Planning Application Reference No.: 3/2023/0664

Address of Development: Dewhurst Road Langho

Planning Application Number: 3/2023/0664 Grid Ref: 369072 434193 Proposal: Construction of two dugout shelter buildings to replace the existing temporary shelters Location: Langho Sports and Social Club, Dewhurst Road, Langho BB6 8AF

**1\* Proposed Ground Floor Level Plan**  
1:20

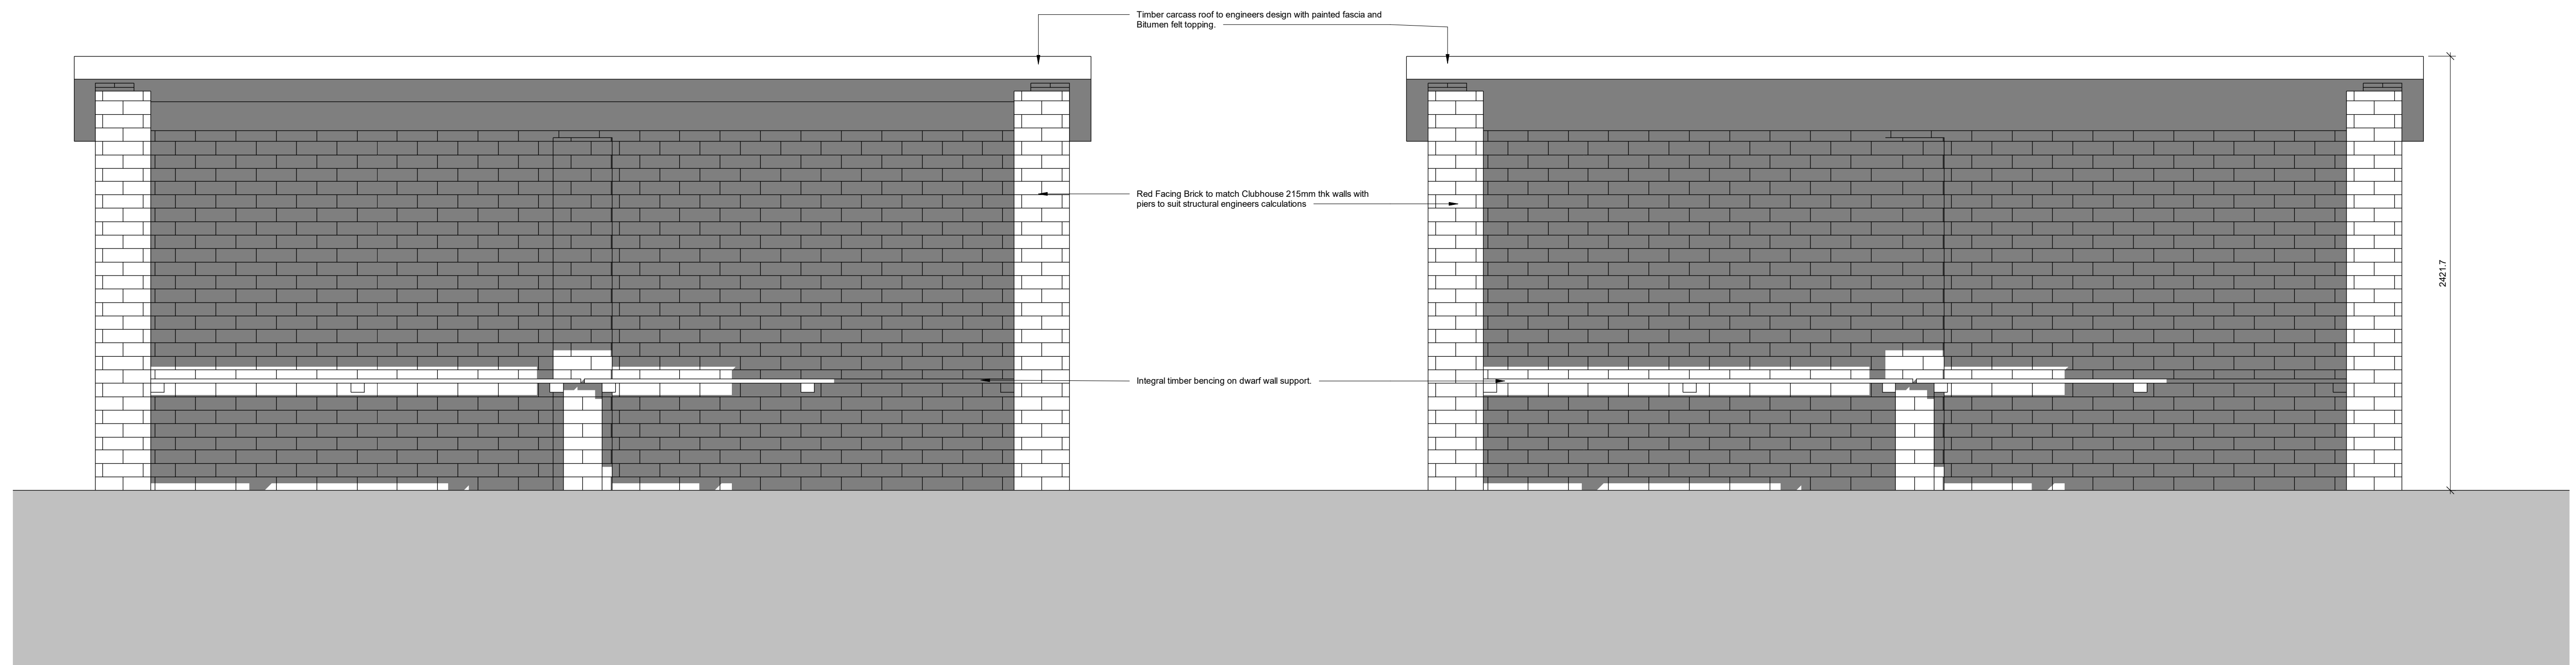
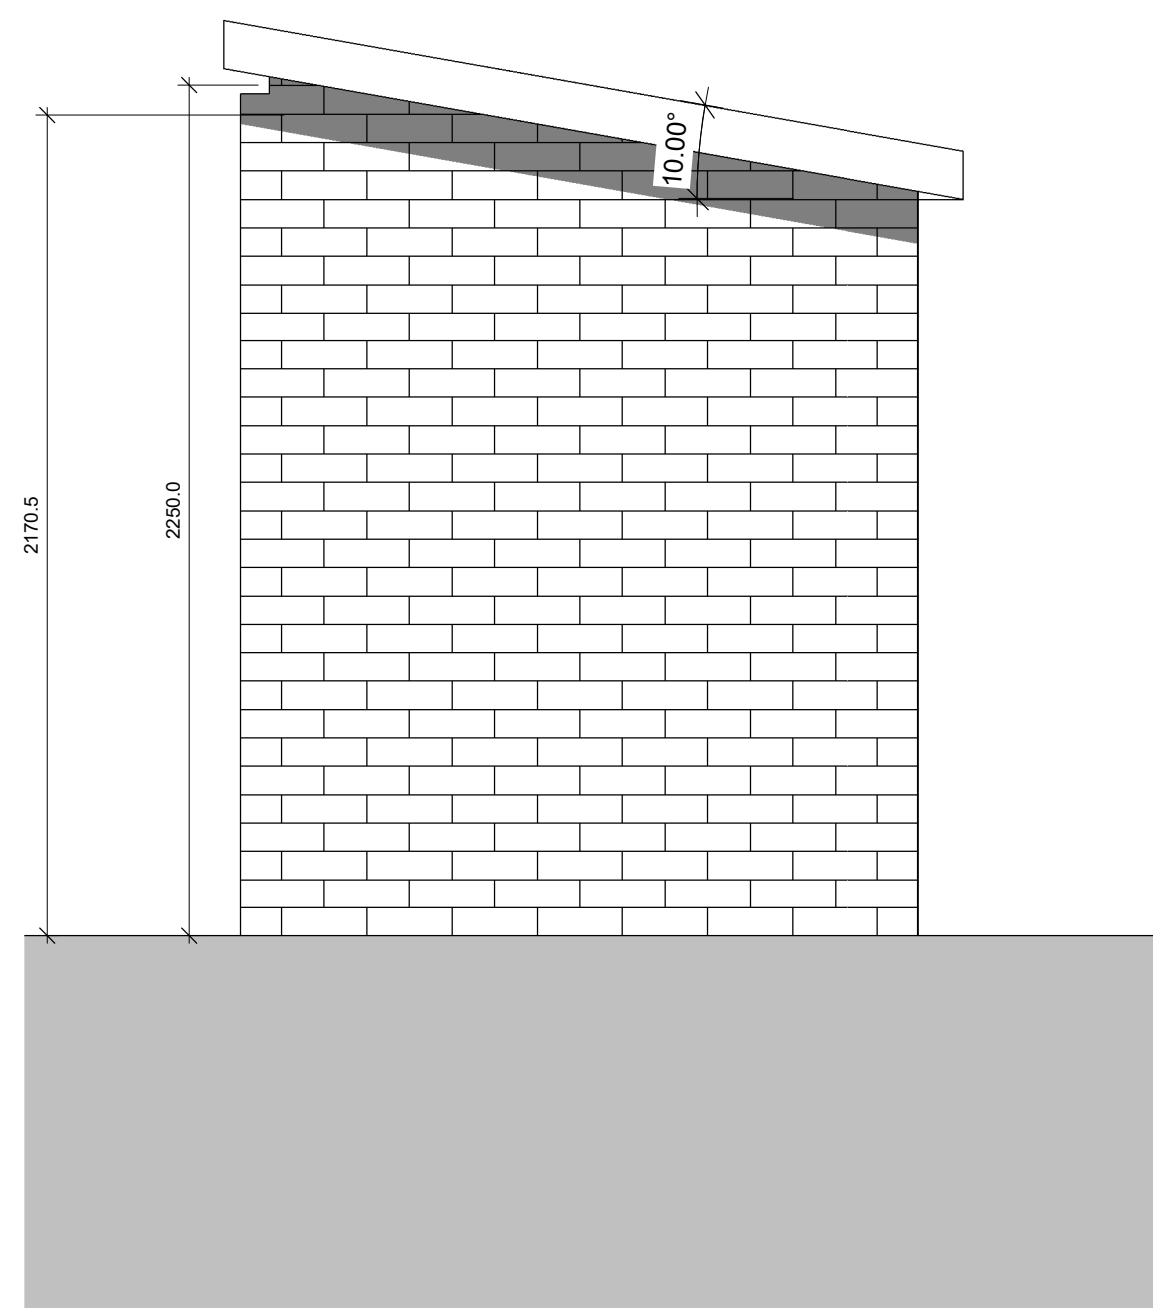
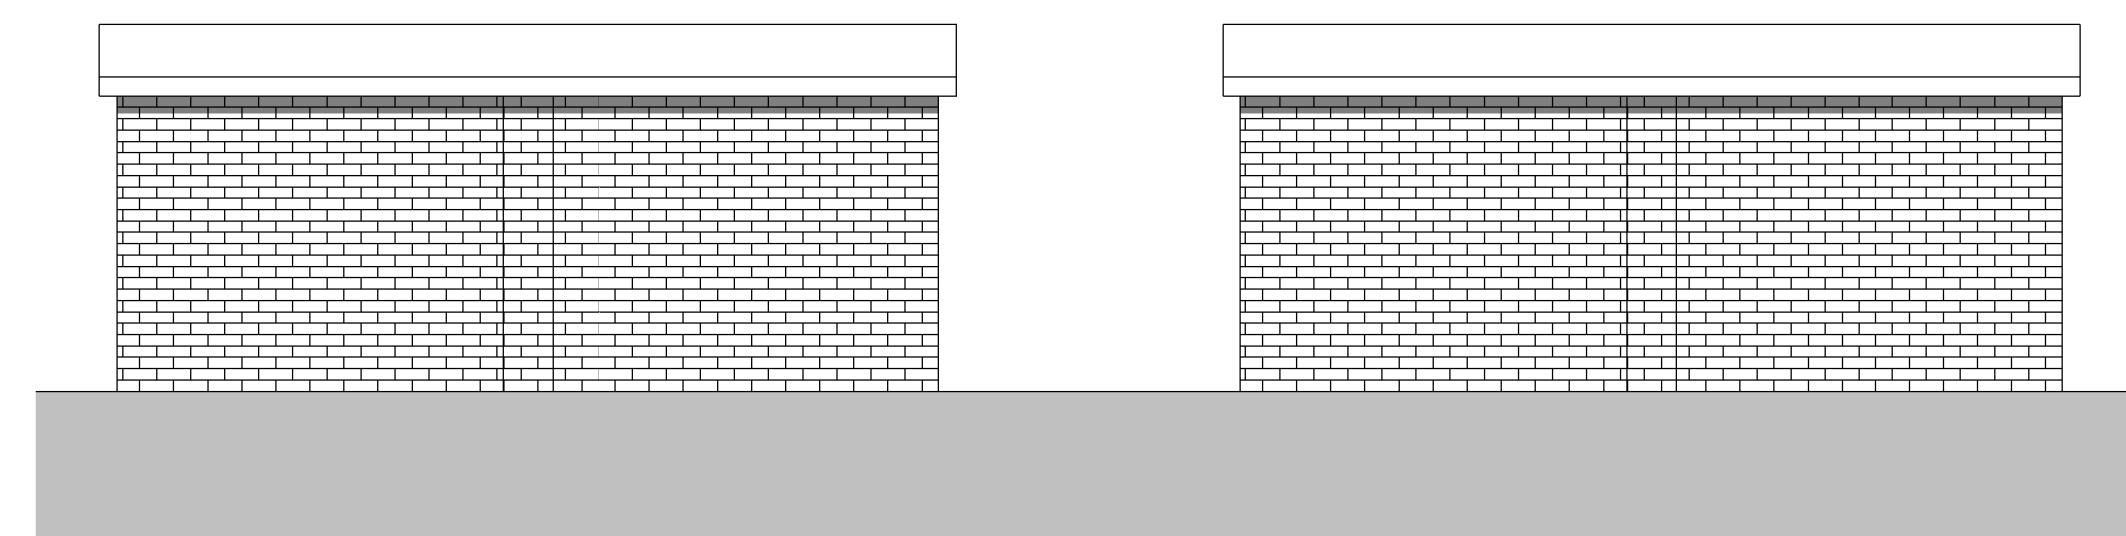
Comments: Langho FC have applied to replace the existing and removable dugouts with 2 significantly larger and permanent red brick dugout buildings, each measuring 5.43c.m long x 1.79m wide x2.42 high

These permanent red brick structures would permanently remove 19.44m2 of our covenanted Community Public Open Space from its covenanted purpose of providing space for recreation of all types. For context the current removable dugouts have a footprint of only circa 2.28cm2 each

Comments: Langho FC have applied to replace the existing removable dugouts with 2 far bigger permanent red brick buildings each measuring 5,43m long x 2.79m wife x 2.42m high

These permanent buildings would permanently remove 19.44m'2 of our covenanted community public space from its covenanted purpose of providing space for recreation of all types. The current removable dugouts take only 2.28m2 each

Langho FC The Rydings proposed site plan

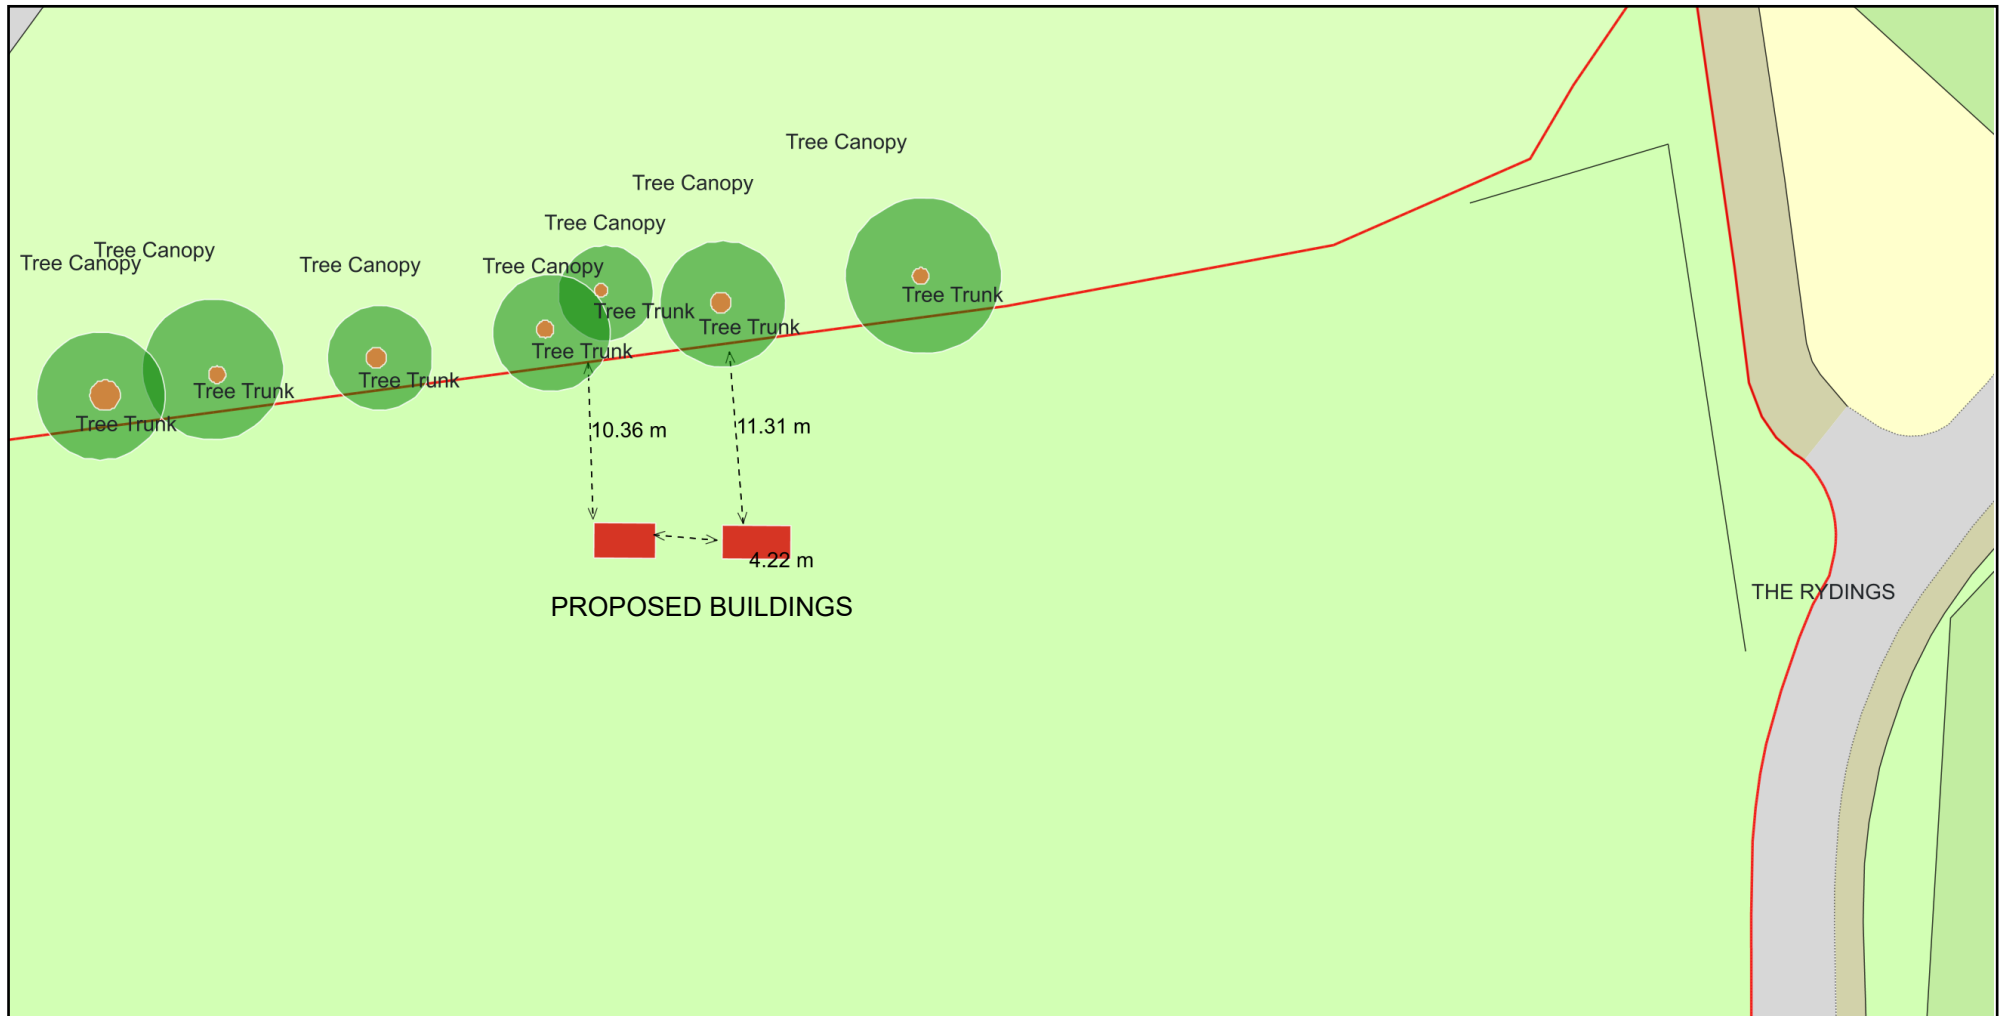
> and a party to a covenant that restricts the land use to that of our recreation. I believe the siting of permanent structures on the land will prohibit wider use as a recreational facility. Whilst the club currently lease the land for football use, by placing permanent brick structures in such a position they are causing a permanent obstruction for other use. The brick structure would also be a safety hazard for other recreational use. On this ground to preserve our covenant, RVBC should not grant planning or landlord permission for the permanent structures.
